Submissions Report

Bass Point Quarry Modification 3

PA 08_0143

May 2022

Figure 3 | Existing and proposed amenity barriers

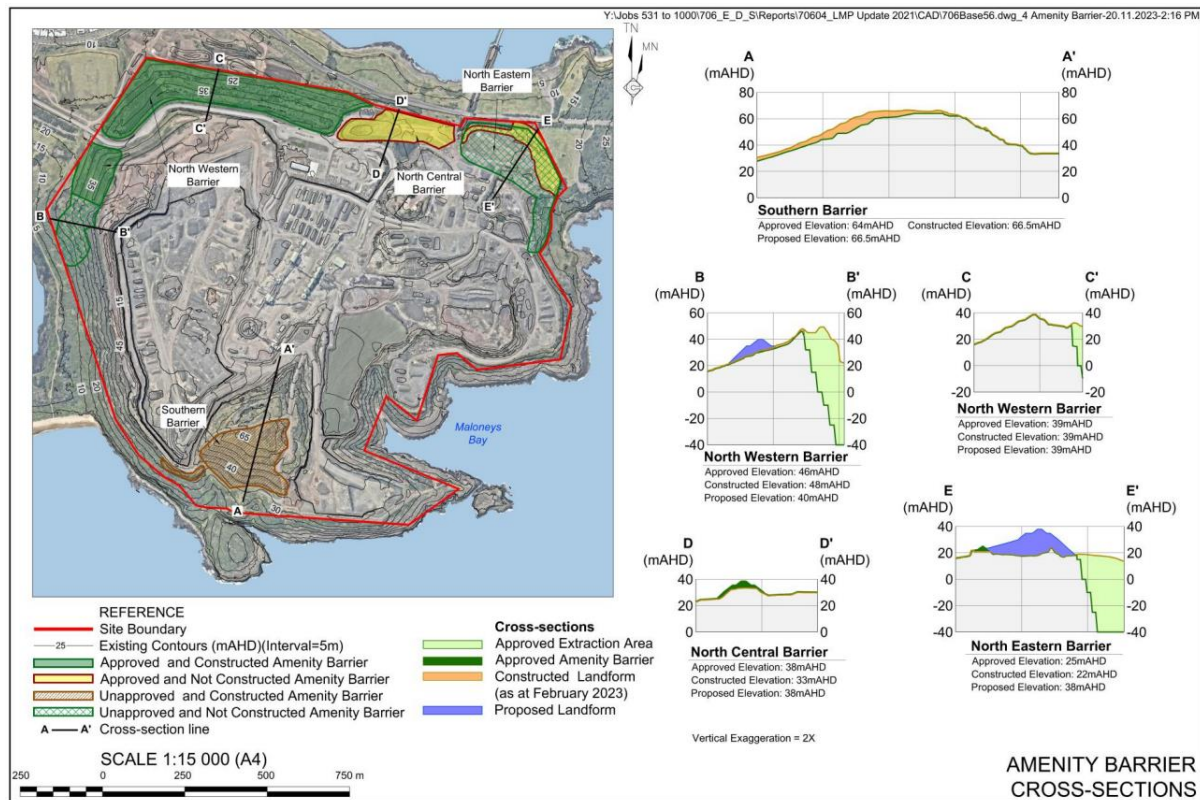
- *Amended plans which clearly identify what amenity barriers exist on the site currently, what additional amenity barriers (or additional height to be added to existing barriers) are proposed to be constructed at the site and what parts, if any, of the existing amenity barriers have current development consent.*

...The visual amenities to be modified or constructed are not clearly detailed in the modification proposal. I am requesting the approval document to be revised to include a diagram that clearly shows existing visual amenities vs the proposed visual amenities, the diagram needs to allow the general public to understand the locations where the visual amenities will be constructed or modified.

An updated version of Figure 4 from the *Modification Report* clearly presenting contour levels, a comparison of approved and unapproved amenity barriers, approved and unapproved rehabilitation areas and areas where construction is proposed to continue is presented as **Figure 1**.

Section 2.2 of the *Modification Report* defines the proposed modifications to the locations and scales of the amenity barriers within the approved Quarry Site to consist of the following.

- Further extension and development of the approved and existing visual amenity barriers to the north-west of the Quarry Site, to a potential maximum extent of that shown on Figure 3 of the *Modification Report*.

- Increasing the extent of the approved visual amenity barrier locations to the north-east of the Quarry Site, to a potential maximum extent of that shown in Figure 3 of the *Modification Report*, and an increase in the approved maximum height from 30m AHD to 40m AHD, where practicable, to allow for a more consistent landform when compared to the existing areas to the north-west.

- Further development of the area in the vicinity of the existing southern visual amenity barrier to a potential maximum extent of that shown on Figure 3 of the *Modification Report*, to allow for increased visual impact mitigation during the latter stages of extraction in the southern areas of the approved extraction area. No change in the current height of the existing modified landform is proposed. The barriers on the southern section of the Quarry Site are not currently approved under PA 08_0143 and consist of land completed and under rehabilitation as well as locations for future material placement and barrier construction.
